Our ref: Greenwich Hospital Redevelopment - Detailed Design-Mod-2 (SSD-13619238-Mod-2)

16 March 2026

Greenwich Hospital Redevelopment – Modification Application (SSD-13619238-Mod-2)

Request for further information

Figure 8 Level 2 wellness area layout, as approved (top) and as proposed to be amended (bottom)

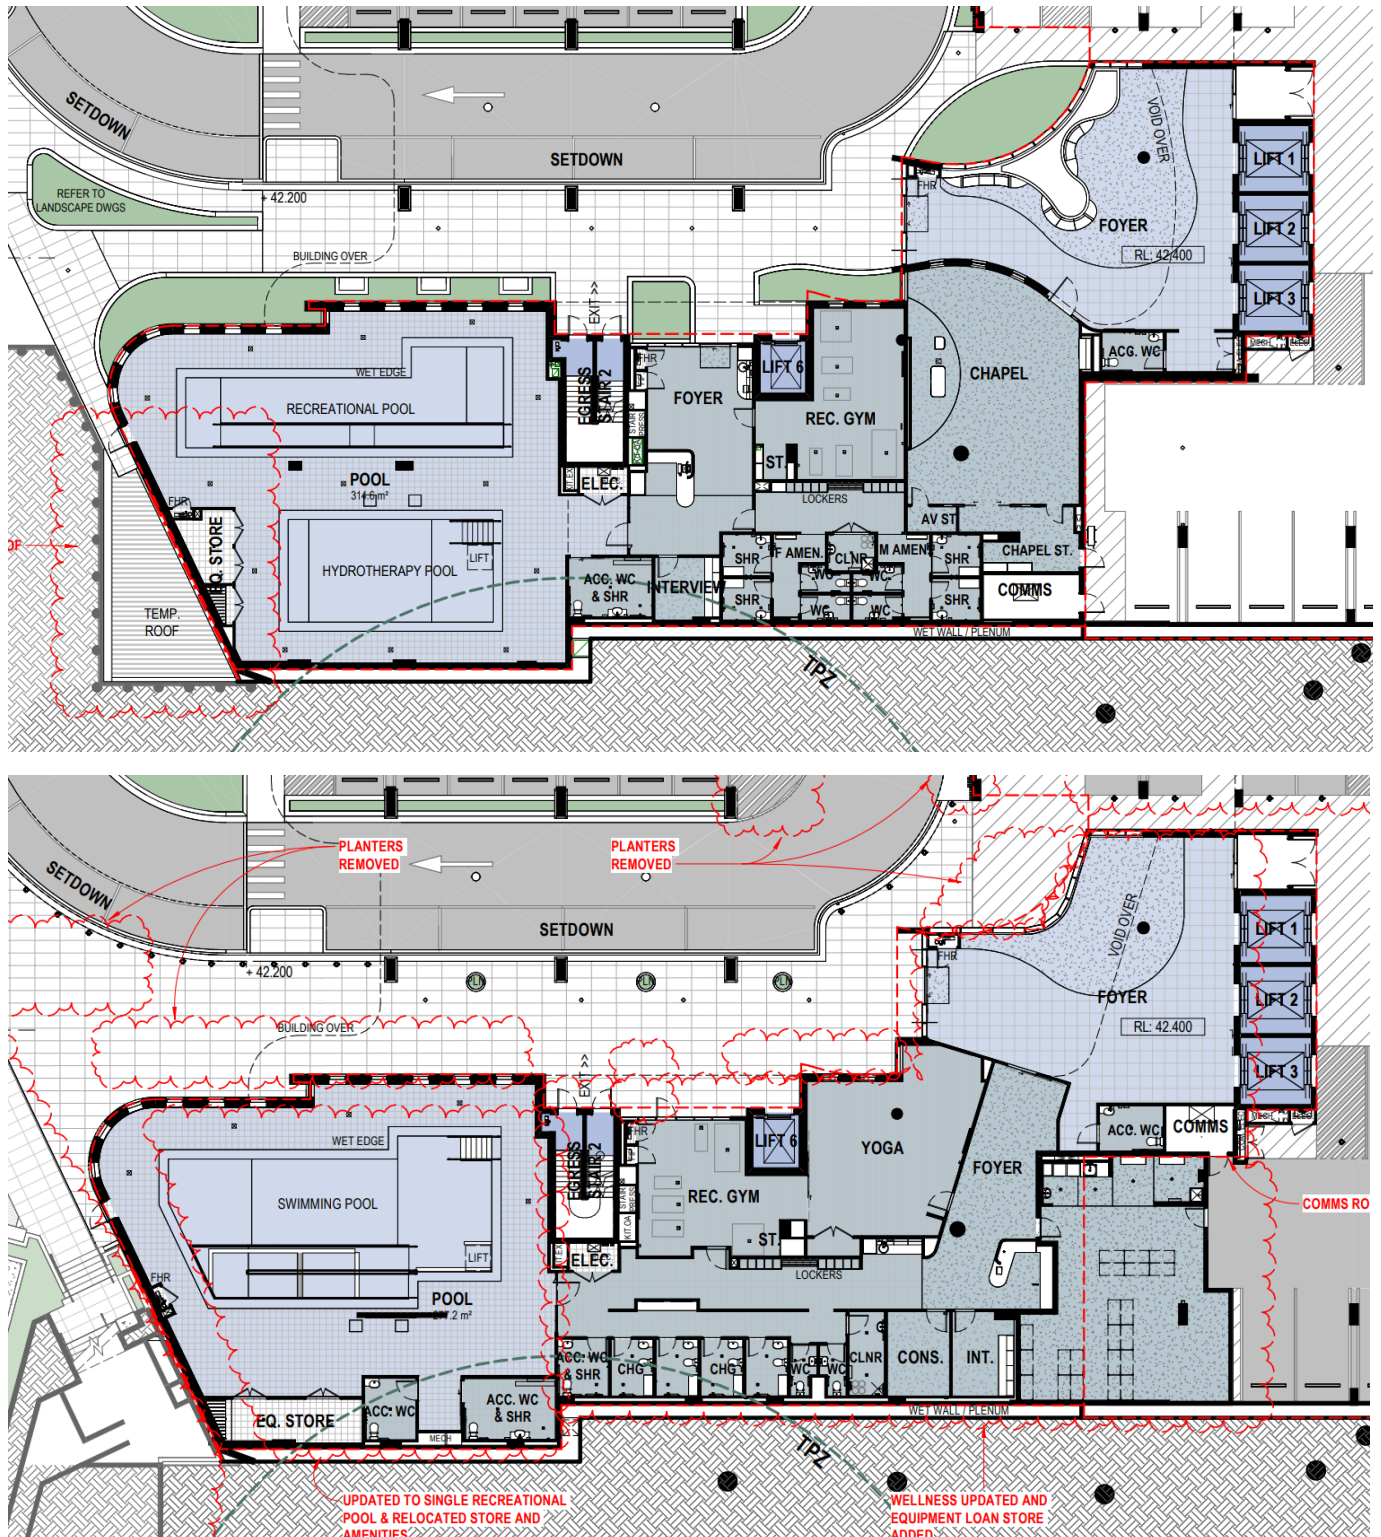
- Outline all landscaping changes circled on the Landscaping drawings provided as part of the modification, and a justification for such changes.
- Provide further details of the exact proposed changes to the boardwalks and any anticipated impacts on vegetation and ecology.
- Outline any changes in areas of Aboriginal significance.
- Please explain the purpose of the boardwalk on the southern boundary of the site, and why is it no longer considered necessary.
- Provide a justification for removing all planters outside of the Health Building, as shown in Figure 8 of the Modification Report.

Figure 4 Aerial Image illustrating northern facades of Seniors Living Buildings  
Source: Bickerton Masters Architecture

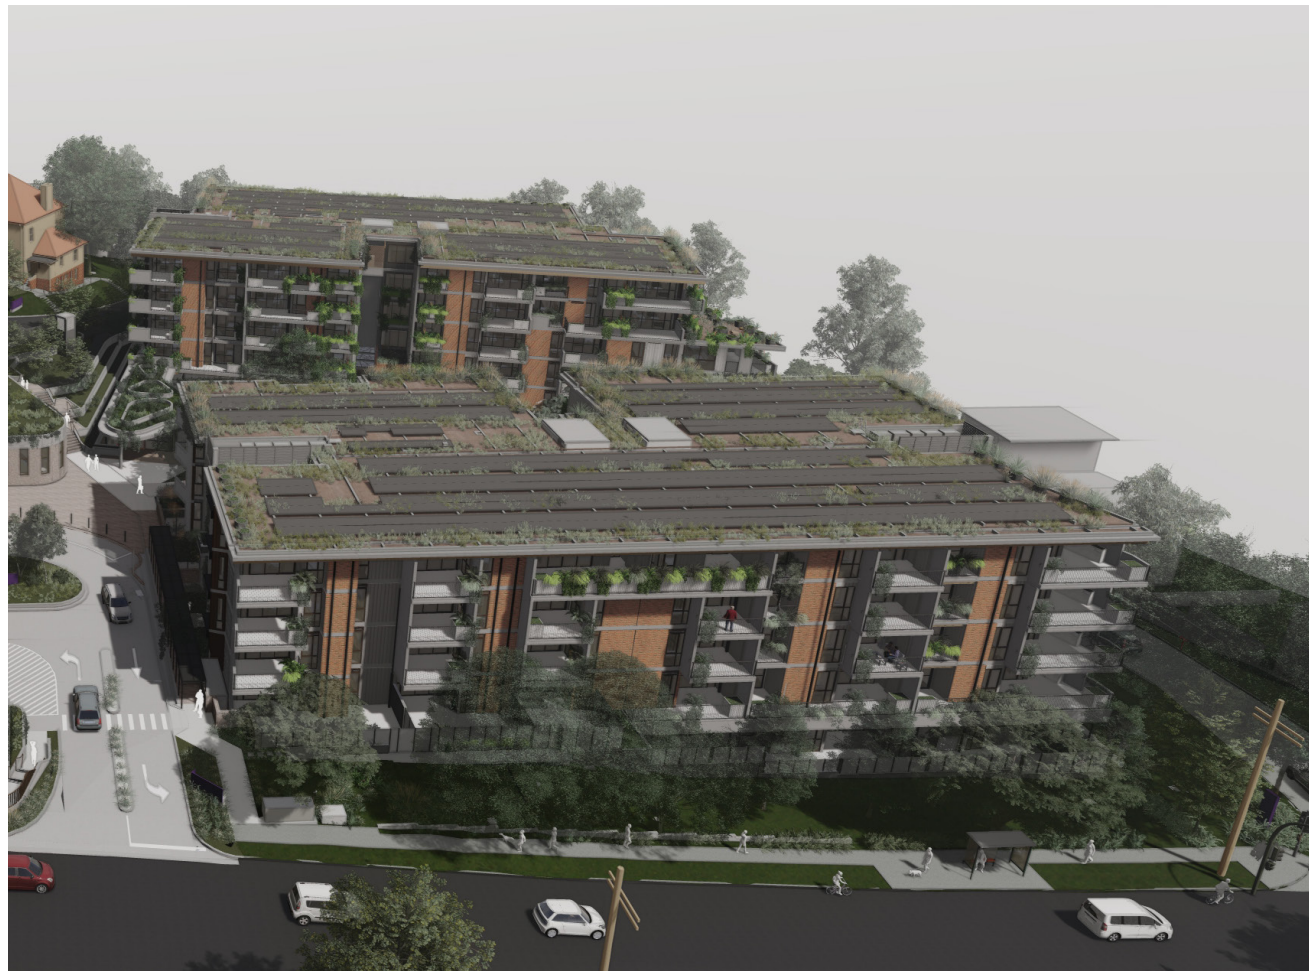
- Provide Architectural plans of the revised renders and elevations for all facades of the two (2) Seniors Living Buildings.
- Provide drawings showing before and after comparison of proposed changes to all facades of the two Seniors Living Buildings.

- Given the proposed changes to the facade and balcony planter boxes, please assess any potential changes concerning visual privacy to surrounding neighbouring properties, in particular, residents to the west and south of the Project.
